WEST SUSSEX COUNTY COUNCIL CONSULTATION

TO:	Arun District Council FAO: Simon Davis
FROM:	WSCC - Highways Authority
DATE:	2 September 2020
LOCATION:	Land west of Fontwell Avenue, Eastergate, PO20 3RX
SUBJECT:	BN/50/20/PL Demolition of existing structures onsite & erection of 42 No. dwellings with access, parking, landscaping & associated works. This application is a Departure from the Development Plan. More information received.
RECOMMENDATION:	No Objection

Transport and highway Access Design drawing showing proposed access details to the site

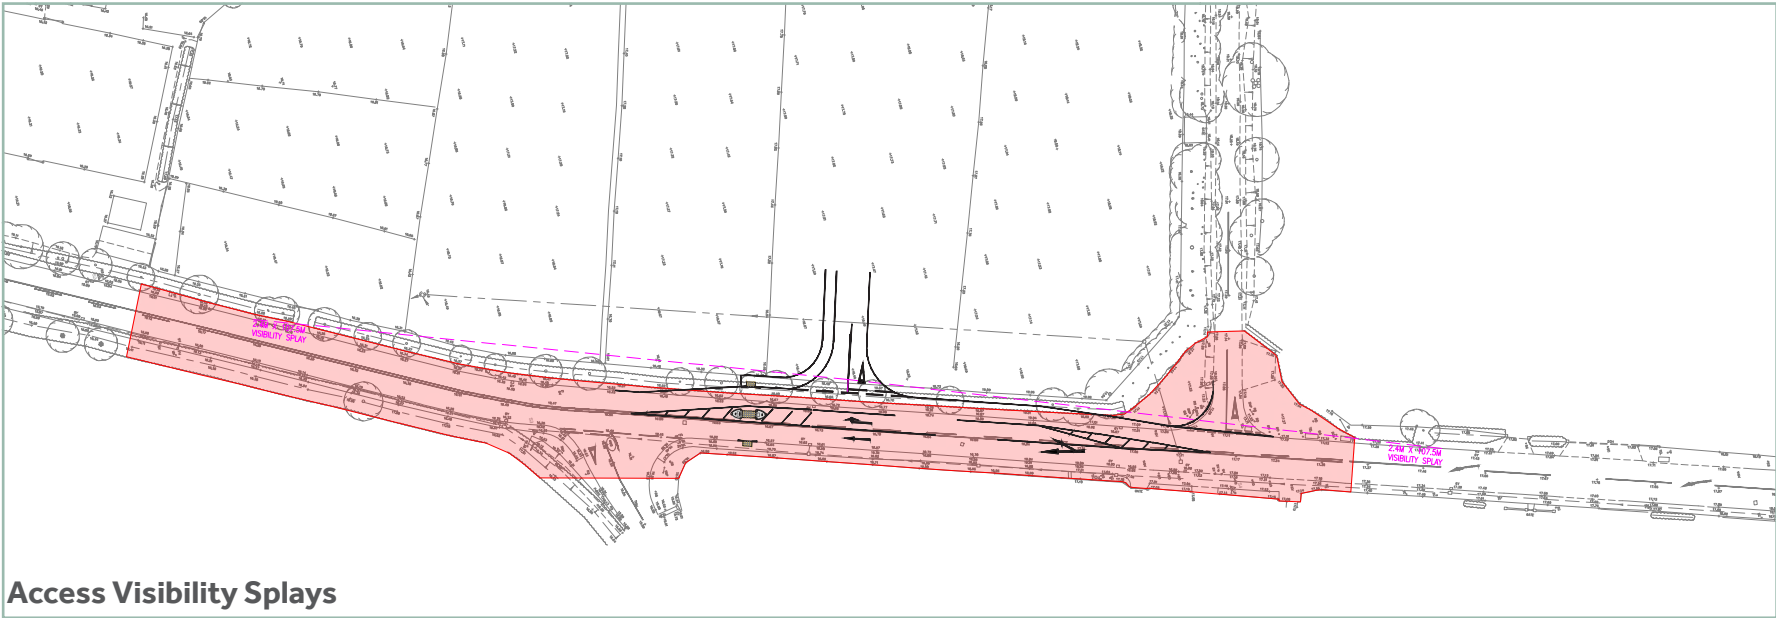
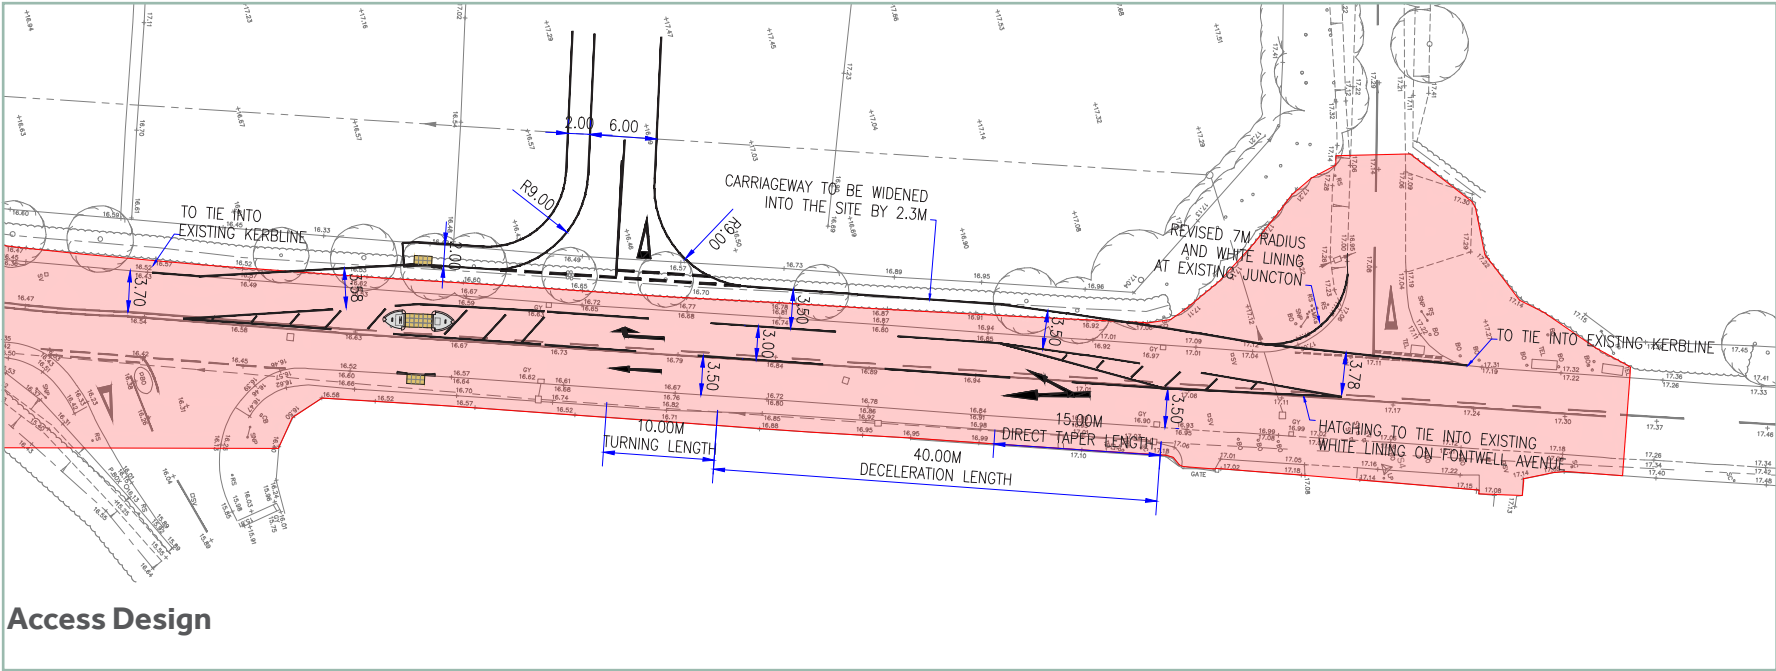
No part of the development shall be first occupied until such time as the vehicular access and associated highways works serving the development has been constructed in accordance with the details shown on the drawing titled ACCESS DESIGN and numbered 020.0360.001.
